21 September 2021

2190140

**Table 1 Summary of Public Submissions and Organisation Submissions**

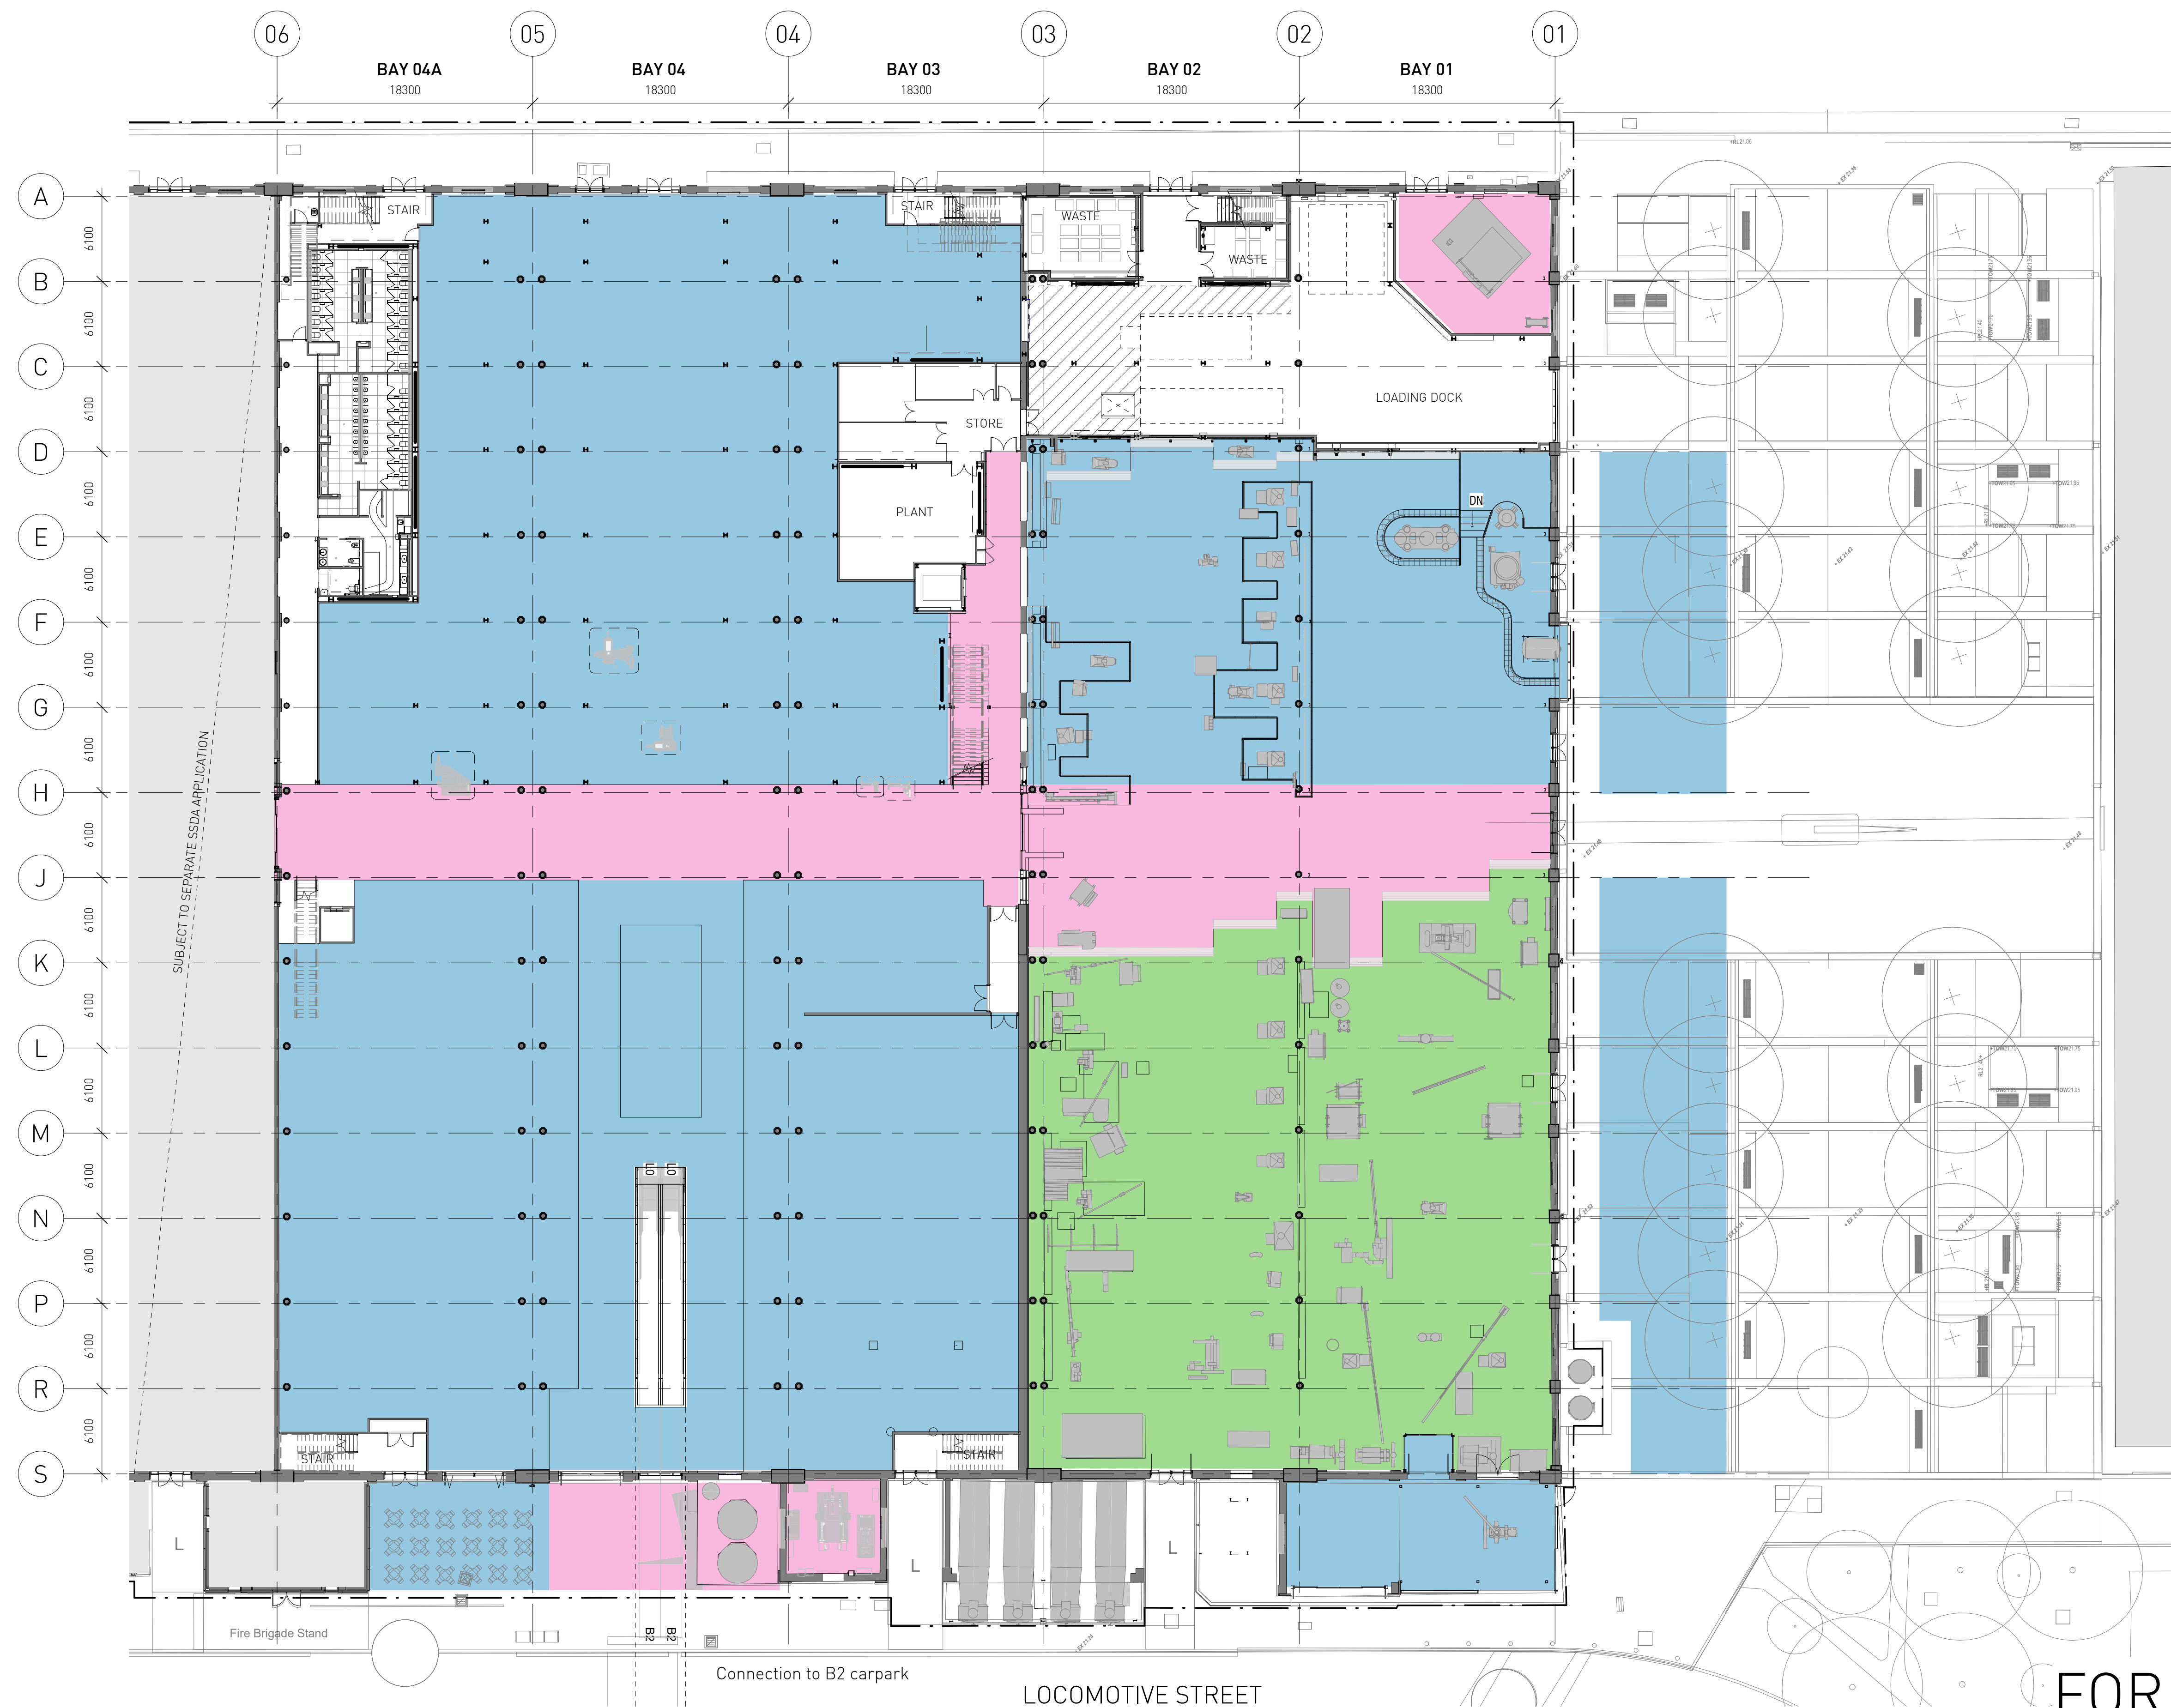
<p><b>Introduction of built structure envelopes and awning structure envelopes</b></p> <p><b>Key Points:</b></p> <p>REDWatch opposes the introduction of built envelopes into public space around the development, as it conflicts with the rights protected under the easement.</p> <p>REDWatch is further concerned that awning structures will adversely impact appreciation of the heritage built form of the Locomotive Workshop and new Loco from Innovation Plaza and other public spaces. Mirvac's proposal for a 3 metre north south strip alongside the building to allow the eastern wall of the Locomotive Workshop to be visible and appreciated is rejected. Such a vista is too narrow and restricted, and the proposed development will interrupt appreciation from everywhere else.</p>	<p>The scale of the proposed build structure envelopes have been scaled back considerably, and the awning structure envelope has been removed. In addition, the width of the transition pathway between the façade of the Locomotive Workshop and the outdoor seating area has been widened and therefore the width of the outdoor seating zone has been reduced. Accordingly, as noted in the RTS letter no adverse impacts upon the heritage views of the Locomotive Workshop are proposed to be generated. However the proposed seating will provide opportunities for people to sit and appreciate the values of the space.</p> <p>The increased in width of the transition pathway combined with the retention of the 26 wide zone between the eastern edge of the outdoor seating zone and the façade of the National Innovation Centre is considered to be a significant width to allow people to easily move through the Plaza.</p>
